Net Zero Teesside Project

Planning Inspectorate Reference: EN010103

The Net Zero Teesside Order

Document Reference: 7.13 Notification of Further Proposed Changes

TITLE
 WORKS PLAN. KEY PLAN
 DOCUMENT REF. 4.4
 WORK NUMBER 5 - WASTEWATER DISPOSAL WORKS

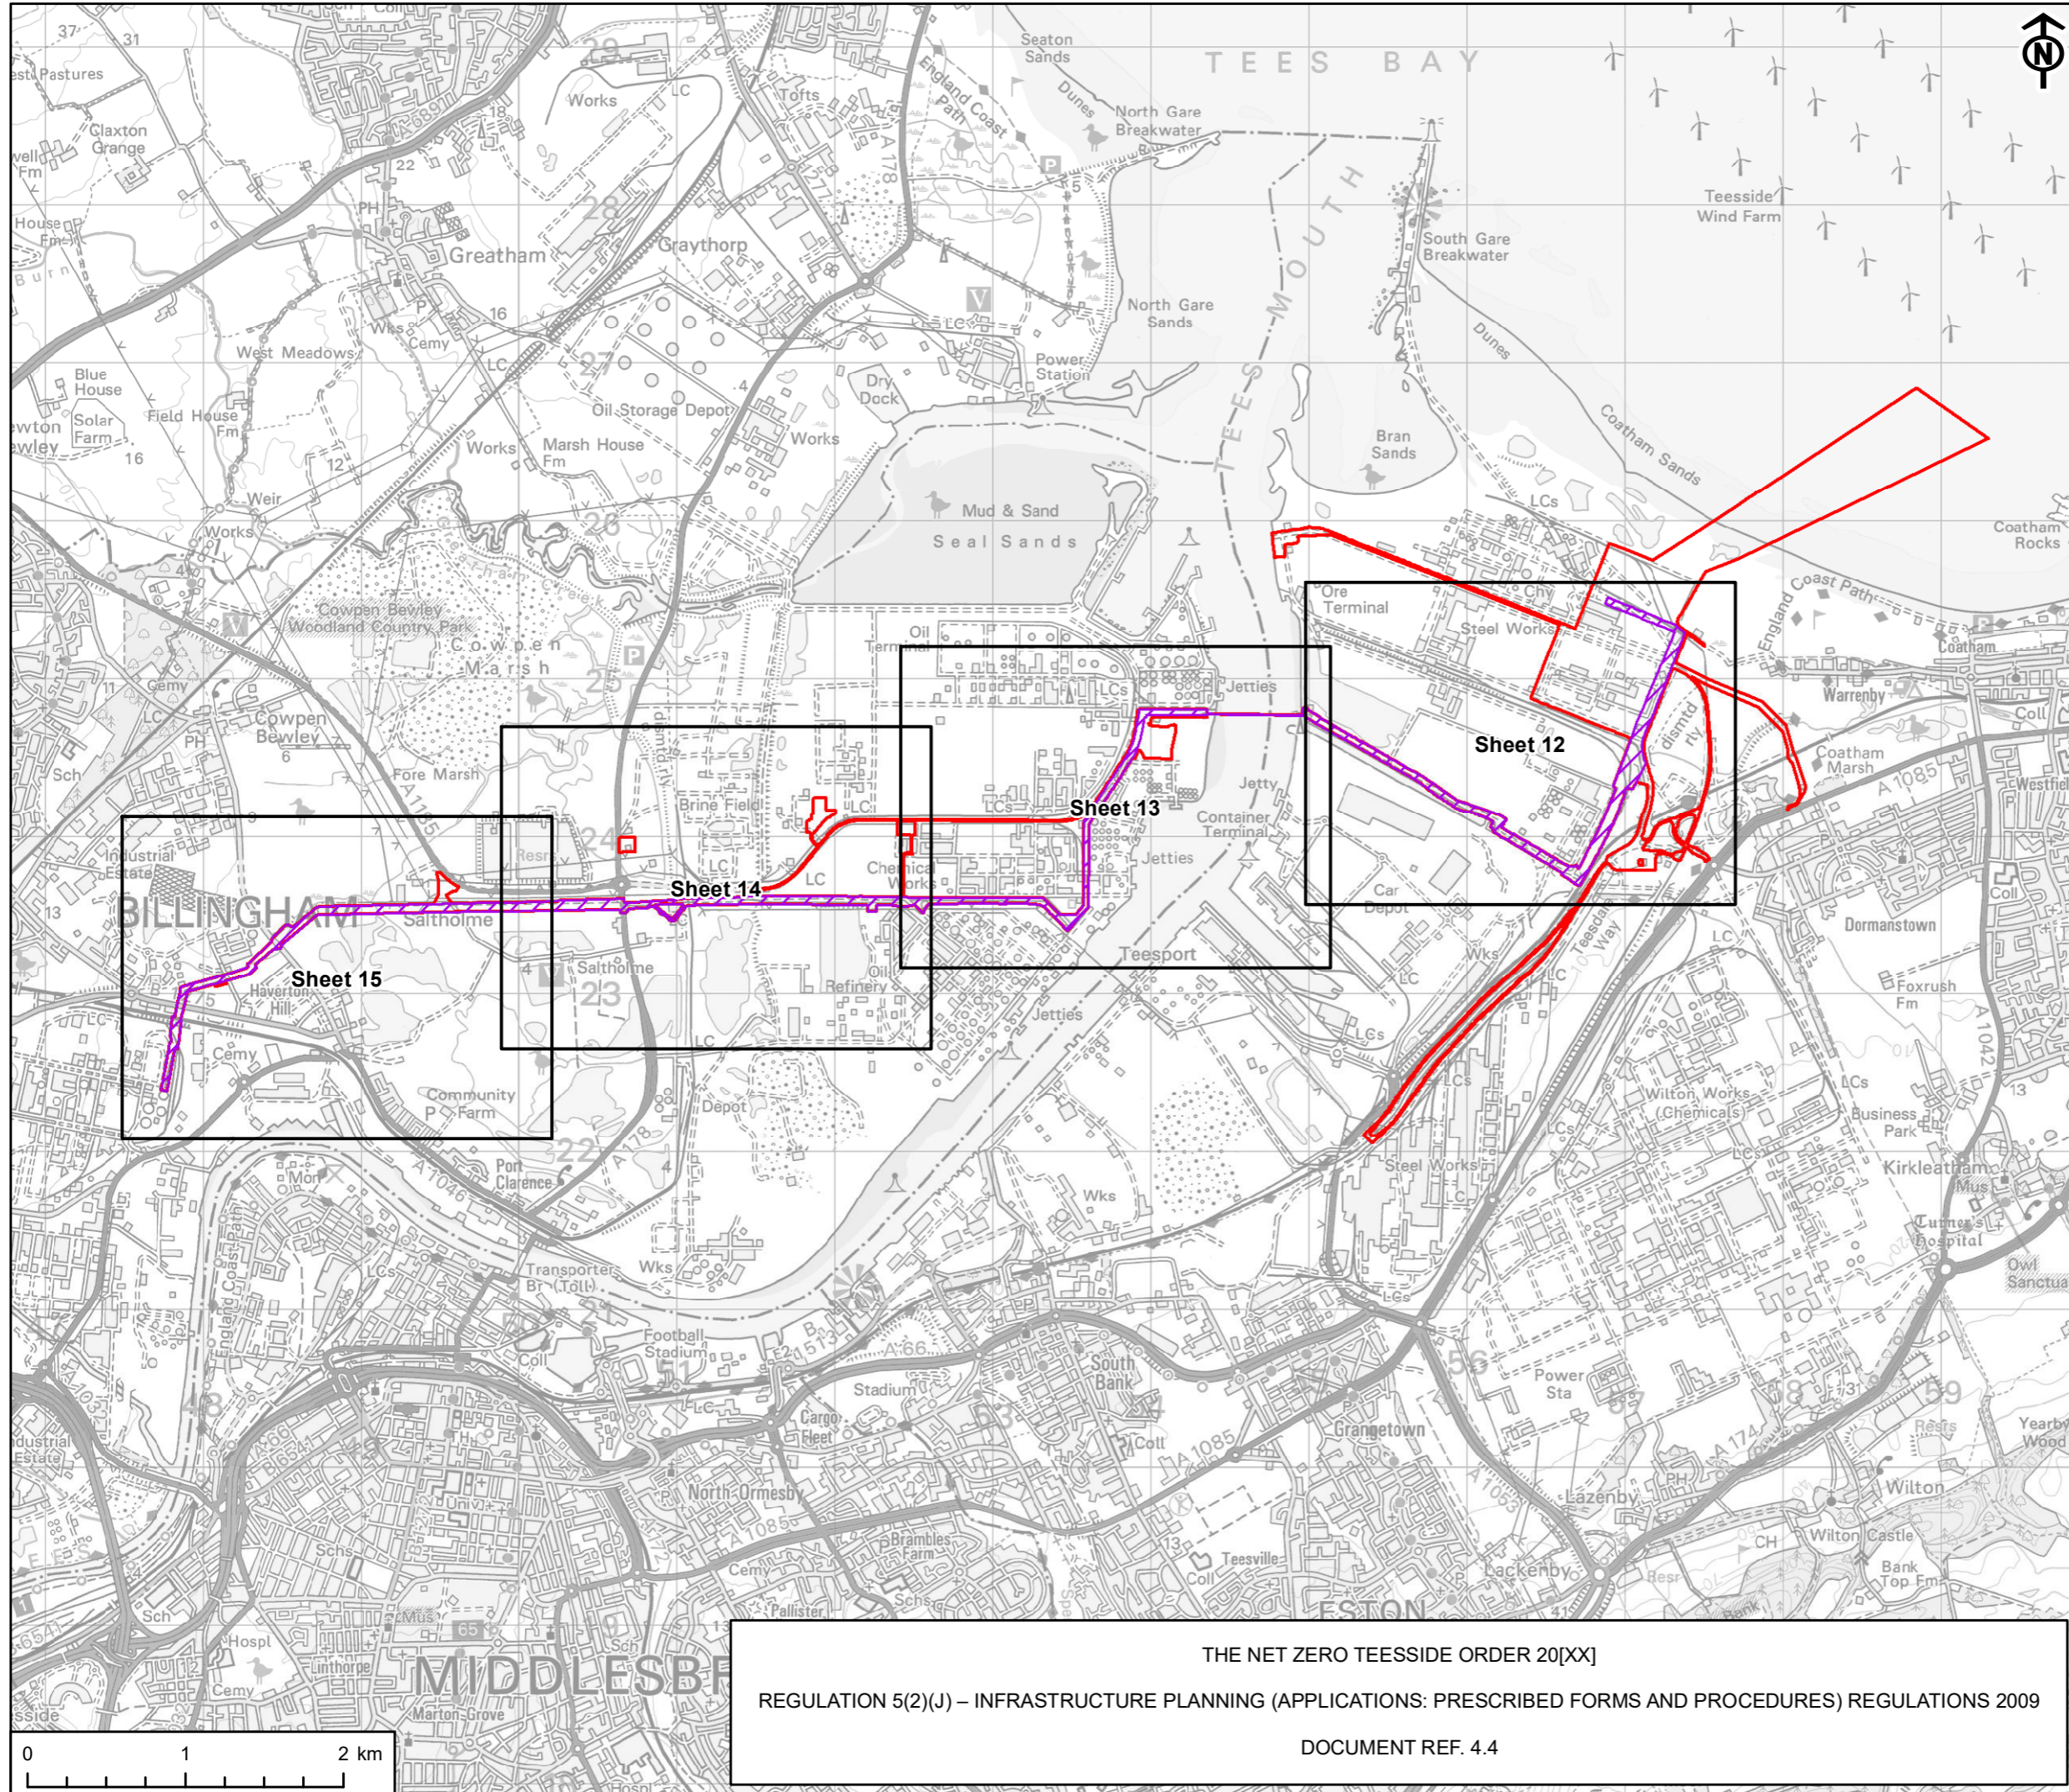
<u>Wastewater Outfall Selection</u>
- 2.3.1 The Applicants confirmed during CAH3 that following completion of technical assessments, they had selected the construction of a new outfall under Work No. 5B and therefore intended to remove Work No. 5A from the Application.

- 2.3.2 The change request for the removal of Work No. 5A would be limited to a reduction in the Order Land/Limits and powers. The Order Land to be removed is for the sole purpose of Work No. 5A, including Plot 305, which is also covered by Work No. 10 (but solely related to activities for Work No. 5A).

- 2.3.4 The change request would result in the removal of complete land plots from the Book of Reference (Document Ref. 3.1), Land Plans (Document Ref. 4.2) and Crown Land Plans (Document Ref. 4.3). The impacted plot numbers are as follows:

- 297
 - 304
 - 305
 - 306
 - 307
 - 308

- 310
- 311
- 312
- 326
- 371
- 2.3.5 The area land to be removed from the Application is shown on the plan at Appendix 1.

- KEY
- Order Limits (Site Boundary)
 - Detailed Sheet Number - Work No. 10 - Access and Highway Improvements
 - Areas within which each Work Number may be constructed:
 - Work No. 10 - Access and Highway Improvements

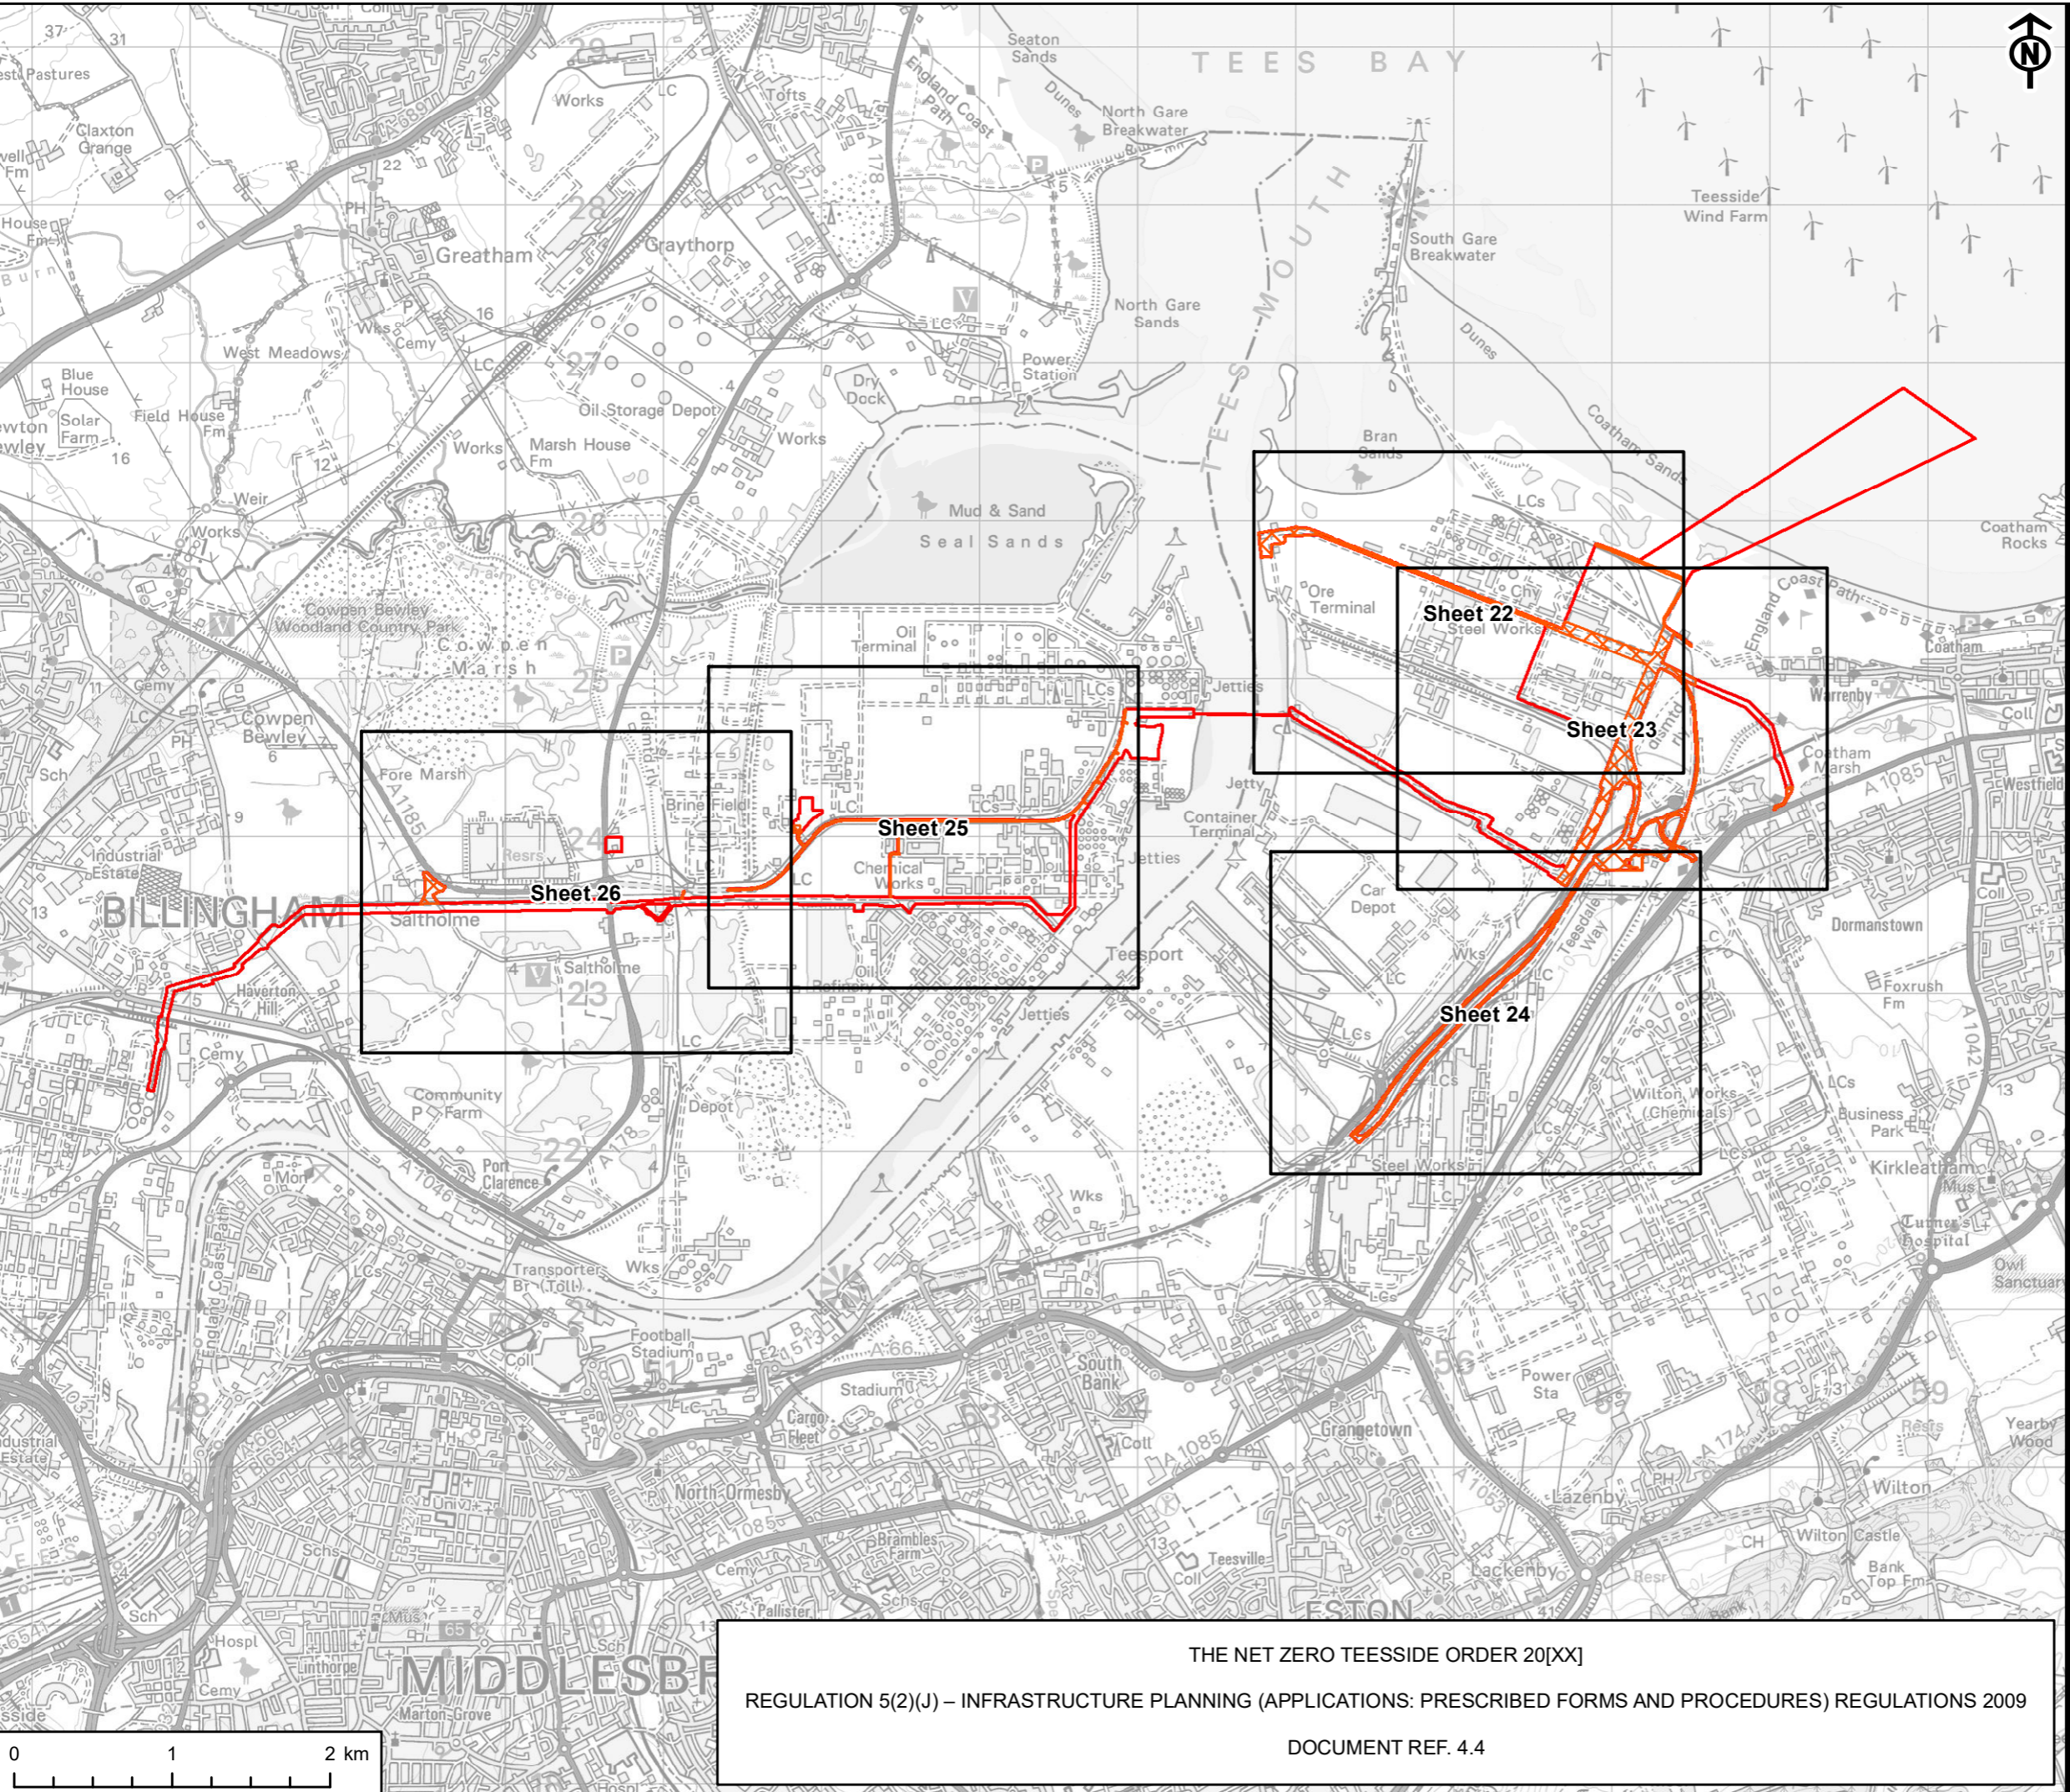
- 2.3.7 Negotiations are ongoing with STDC and therefore the Applicants are not in a position to remove the Tees Dock Road Access plots from the Application at this stage. However, the Applicants intend to request that the relevant plots be removed from the Application upon securing the alternative Lackenby Steelworks Gate Access Route via a legal agreement with STDC, but consider this is now likely to fall after the end of the Examination.

- 2.3.8 The change request for the removal of the Tees Dock Road Access would be limited to a reduction in the Order Land/Limits and powers. The areas which would be removed relate solely to Work No. 10.

- 2.3.10 The Applicants have engaged with STDC on the extent of the change and have agreed the Order Land that would be removed if the change was brought forward by the Applicants. In summary, all of Plot 274 and part of Plot 279 would be removed.
